**2025/0121 - GATEWAY 36 PLOT 7, LAND SOUTH OF DEARNE VALLEY PARKWAY HOYLAND
RESPONSE TO DESIGN, LANDSCAPE AND VISUAL IMPACT COMMENTS**

Thank you for your email of 30 October 2025 including the comments of your urban design officer and landscape consultant on the above reserved matters application for an employment building (amended proposal).

**334 - Gateway 36**  
**Rockingham, Barnsley**

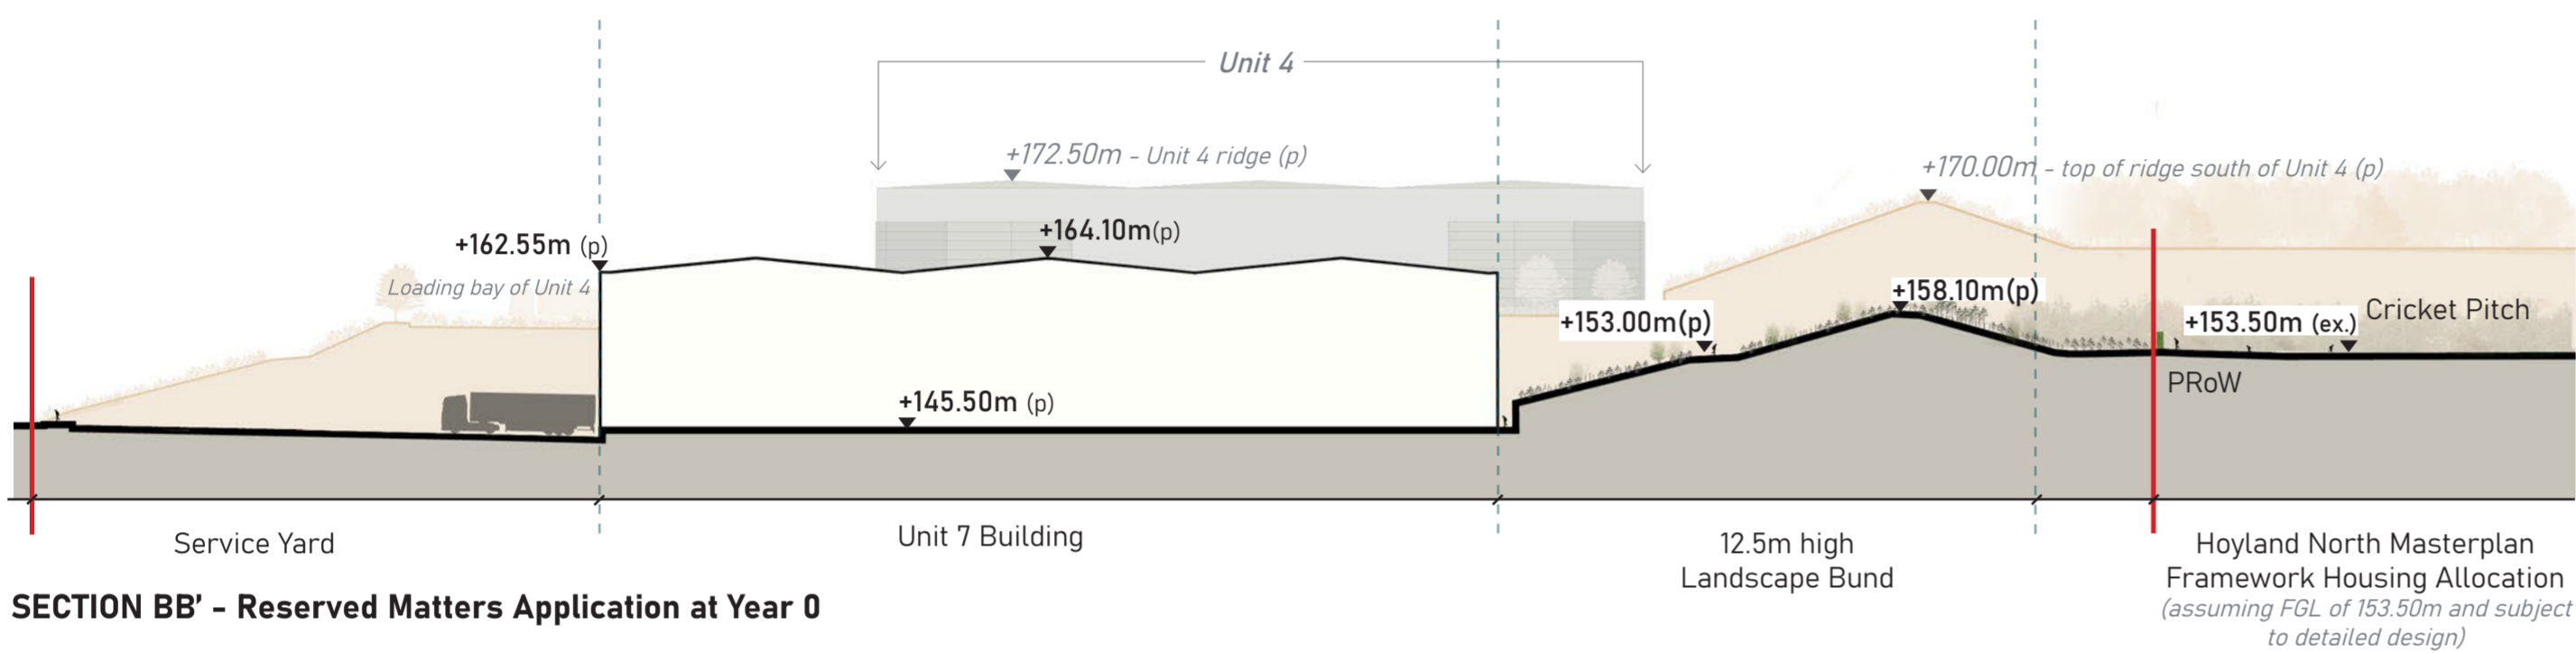
As requested, we respond to the comments of the Urban Design Officer including those relating to any effect of the development on the adjacent land allocated for housing development.

We note that these section lines do not capture the adjacent housing allocation site, but also that the details of the housing scheme are not known (i.e. ground levels, retained/proposed landscape buffers, arrangement and orientation of dwellings and open space).

Our landscape architect has therefore prepared extended and supplemented versions of these section lines which are appended to this note and explained below.

Section BB corresponds to Section 2 and shows the relationship between the proposed Unit 7 building and the adjacent housing allocation site in the location of the open space (cricket pitch) as shown on the Hoyland North Masterplan Framework drawing.

Section AA corresponds to Section 1 and shows the relationship between the prospective Unit 8 building and the adjacent housing allocation site in the location of the area identified for housing as shown on the Hoyland North Masterplan Framework drawing. This shows a distance of approximately 65m from the building to the position of a house on the adjacent site (allowing for back garden to site boundary).

However, it is crucial to note that there is no proposal for the housing development to confirm the ground levels and position of houses. The indication presented is therefore based on reasonable assumed ground levels and siting, intended to present a 'worst case' scenario.

In both cases, the same section line is presented with outline parameter data and the reserved matters proposal, both at Year 0 and Year 15. This allows comparison with the original approved extent and shows the effect of mature landscape planting.

Whilst there may be visibility of the employment development from the housing allocation site (which is not unusual), taken with the landscape bund and planting proposed within the employment site (and notwithstanding landscape planting that may reasonably be expected in the housing site), this is not considered to prejudice the setting of future housing or constitute a harmful impact.
